Department of Planning, Industry & Environment
4 Parramatta Square
12 Darcy Street
PARRAMATTA NSW 2150

Hills of Gold Wind Farm (SSD-9679) – Supplementary Submission

Further to Council's submission dated 29 January 2021, we would like to raise the following additional concerns with the proposed Hills of Gold Wind Farm project (SSD-9679).

Photomontage 10 (HOG01)

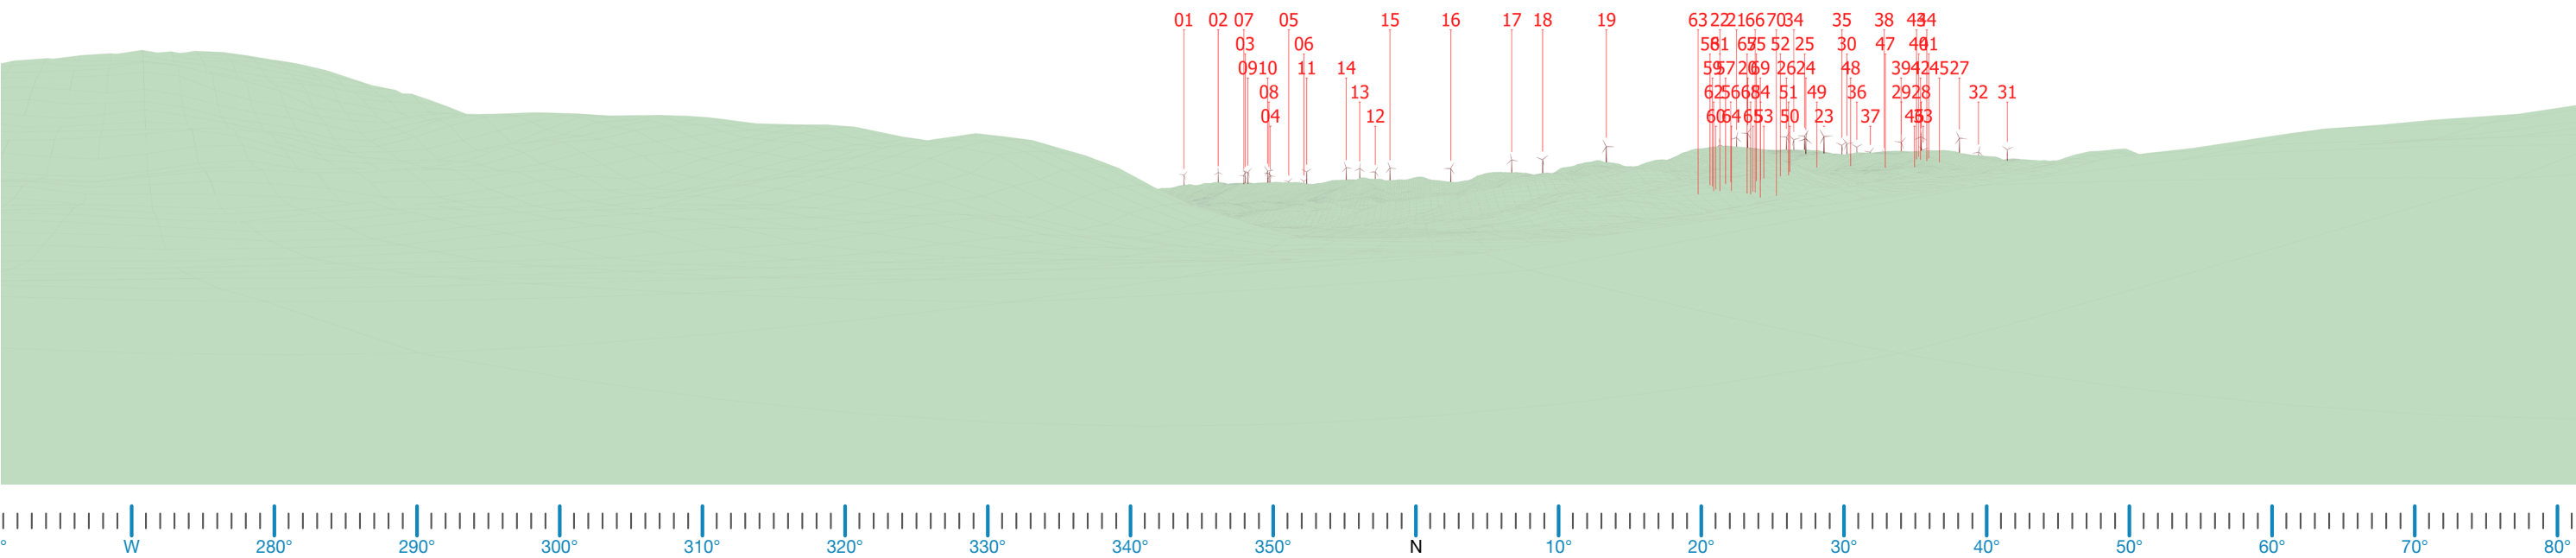
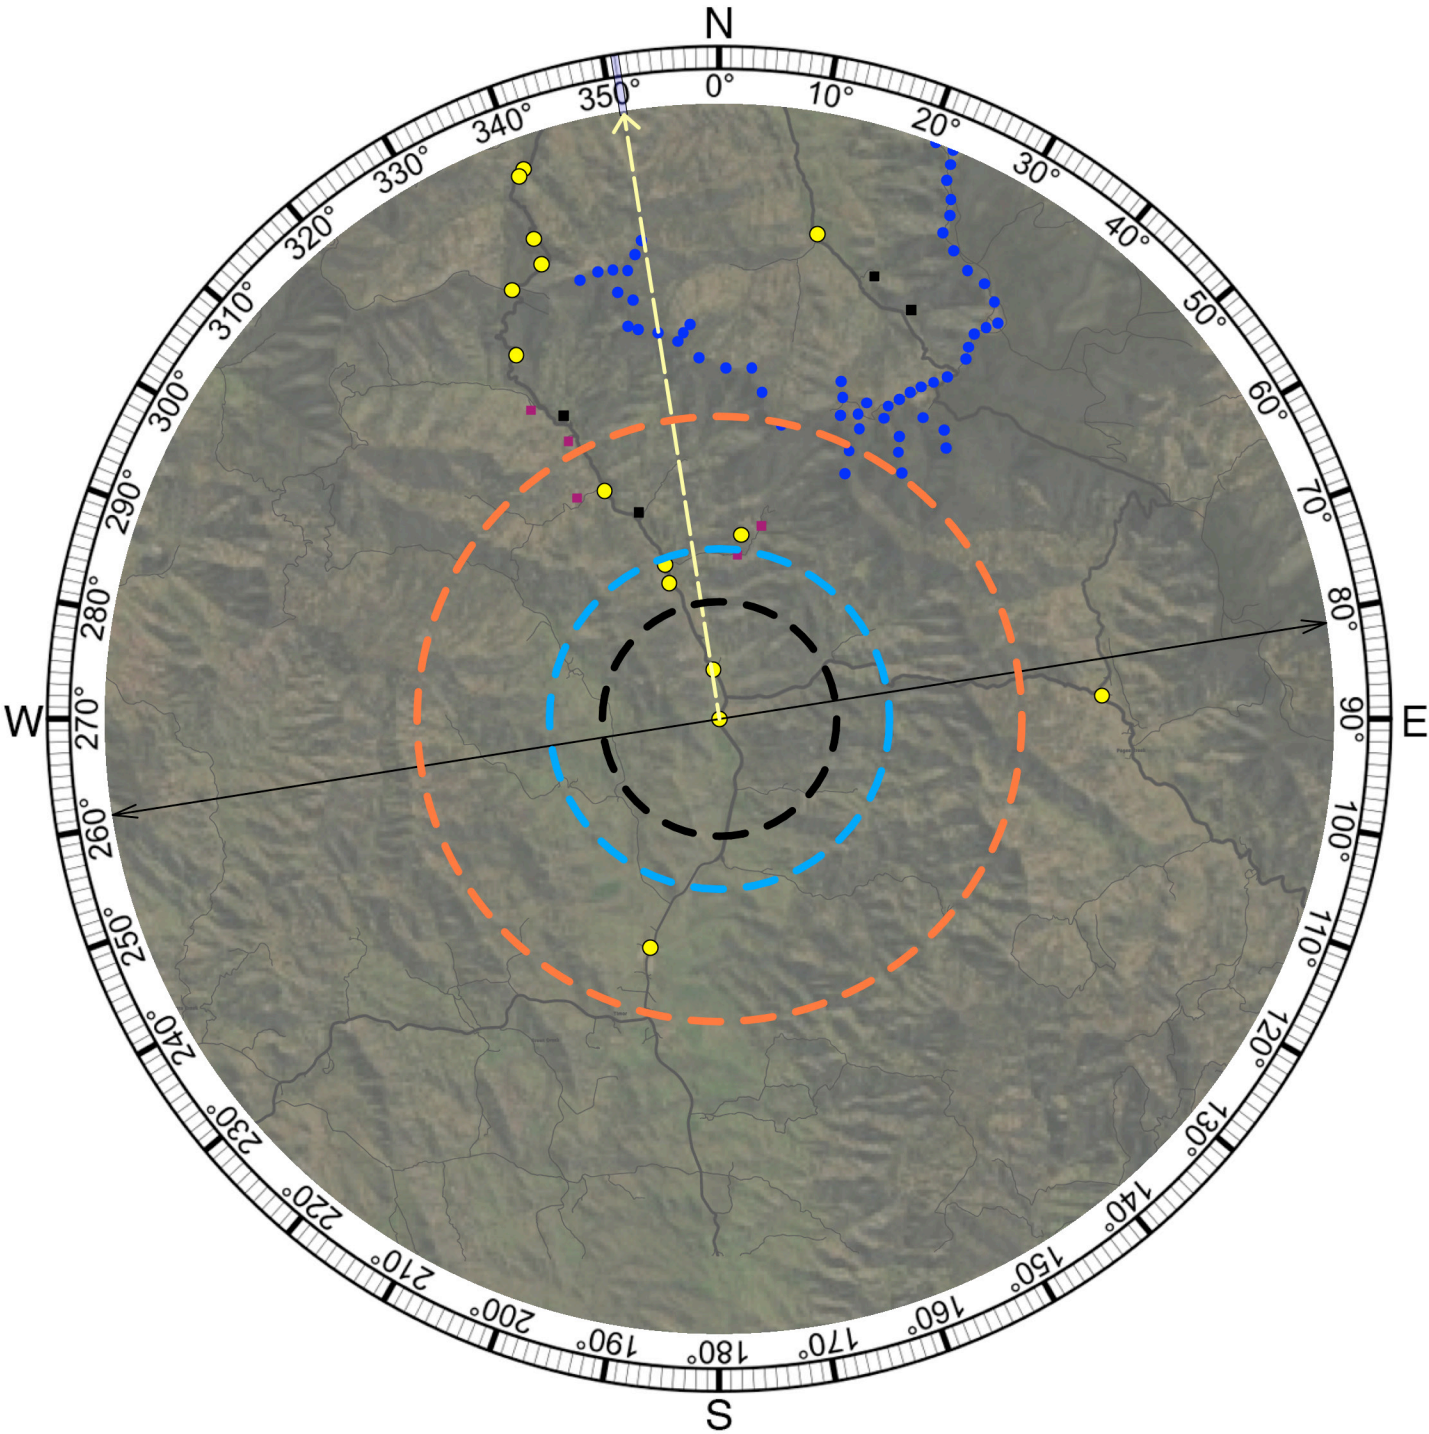
| C. Cumulative Impact | The design guidelines state that ridgelines dominated with wind turbines will not be favoured. The proposed development does not comply with this requirement with a number of the photomontages contained in the Visual Impact Assessment (eg Photomontage 10) clearly depicting ridgelines dominated by wind turbines. It is recommended that the proposal be amended by reducing the number of turbines to ensure ridgelines are not dominated. |
